Recommendation Report for Planning Permission for Works or Extension to a Dwelling

REF NO: LU/36/22/HH

LOCATION: 1 Coleridge Crescent
Kingley Gate
Littlehampton
BN17 7FJ

PROPOSAL: Single storey side extension.

21/4855/2

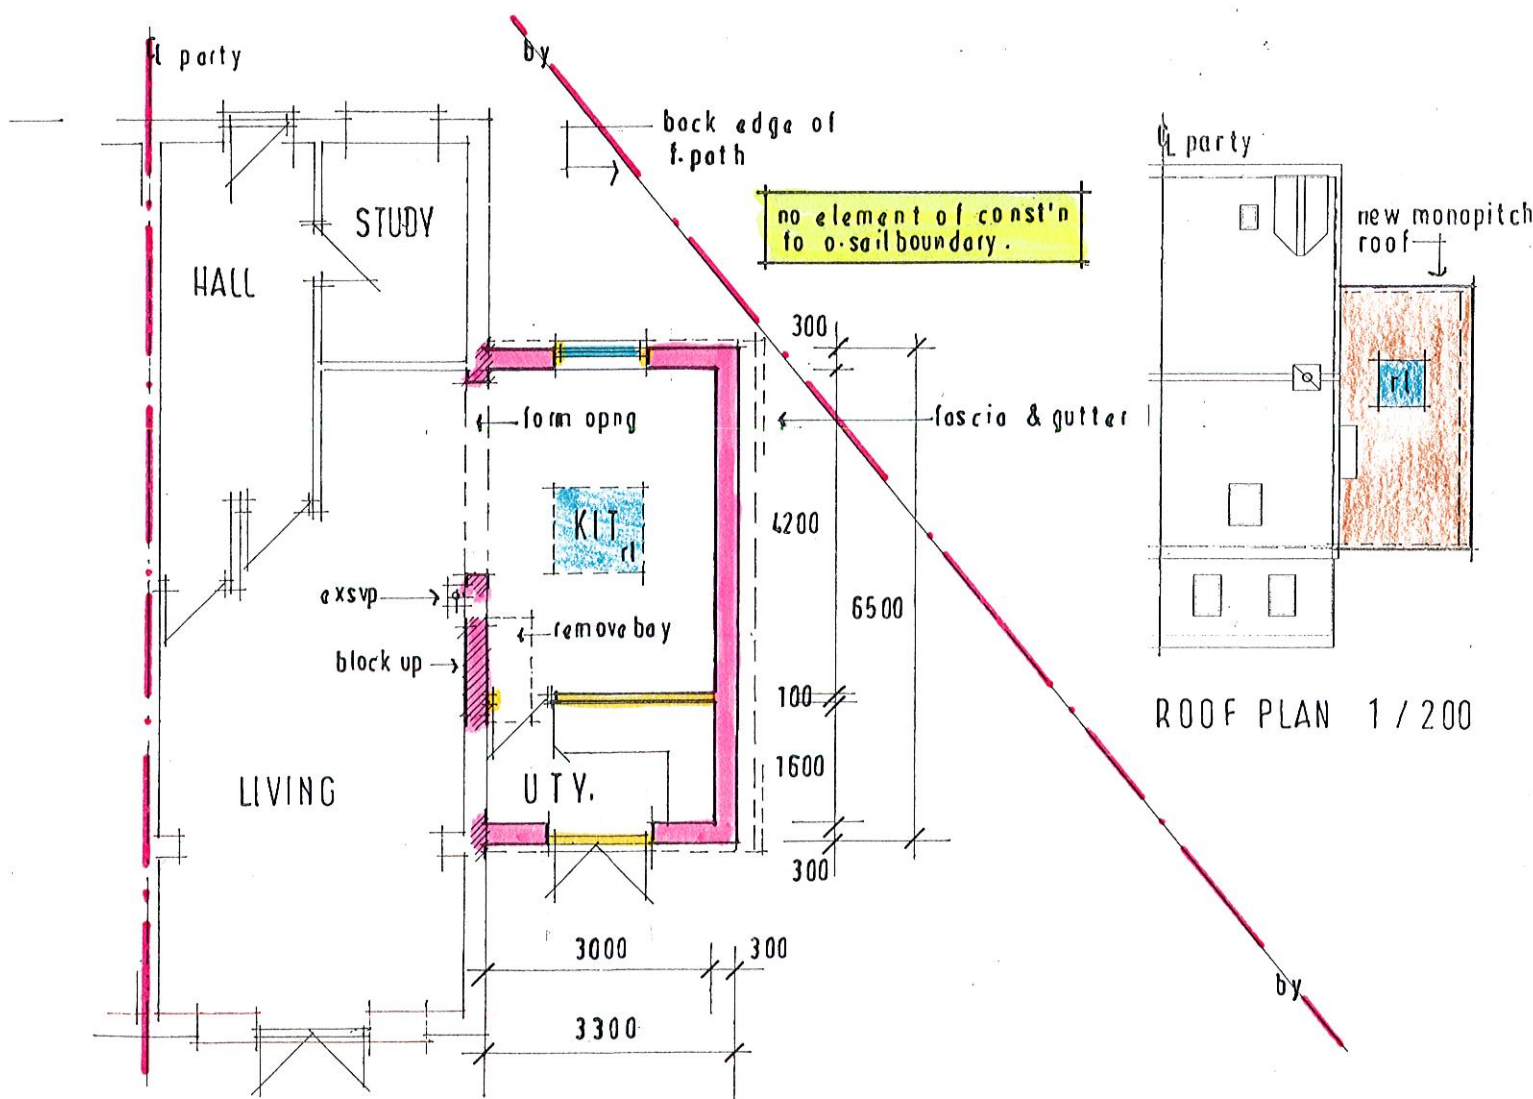
DESCRIPTION OF APPLICATION This application seeks to erect a single storey side extension that is 6.5m in depth, 3.3m in width and 3.5m in height.

The proposal is of moderate scale relative to the host dwelling and considered visually subservient. It is a single storey side extension that features a shallow pitched roof design and matching materials to those found on the existing dwelling. The proposal is visually integrated with the host dwelling. The siting of the proposal is such that the extension is very prominent within the street scene, being located on a side 'strip' of land that is external to its rear garden wall. The proposal would capitalise on this outer 'strip' of land as although it is within the curtilage of the property, it is external to any privacy offered by its rear garden wall as it does not surround the boundary. Although the proposal would be prominent within the street scene, the visual impact is not considered to be significantly adverse, owed to its matching external finishes, subservient scale and being set back from the front elevation by approx. 3m. Additionally, the proposal would make efficient use of a section of the curtilage that is unique in scale to this dwelling and currently, may not able to be readily enjoyed due to its lack of privacy.

This proposal is in keeping with the design of the single storey rear projections/garages that are featured on the existing dwelling and other dwellings around Coleridge Crescent. Furthermore, the materials and external finishes are to match the host dwelling and the brickwork walls. The roof pitch will match that of the detached garage sited approx. 4m to the South of the proposal. As a result the extension will not have an unacceptable negative impact on the street scene.

Section M of the Arun Design Guide sets out the '45 degree rule' which regards 45 degree sightlines and light accessibility lines from neighbouring viewpoints. The proposal is of single storey and to the South (side) elevation which is not neighboured by any dwellings. As such, there is no intersection of any 45 degree sight lines and there are no adverse impacts by way of overshadowing or overbearing on neighbouring amenity space.

There are to be 1 No. front facing window and 1 No. set of rear glass doors. The front facing window is to look out onto the street and as such, will give no rise to adverse impacts by way of overlooking on any neighbouring amenity space. The set of rear glass doors look out to the rear garden and as such, also give no rise to adverse impacts by way of overlooking.
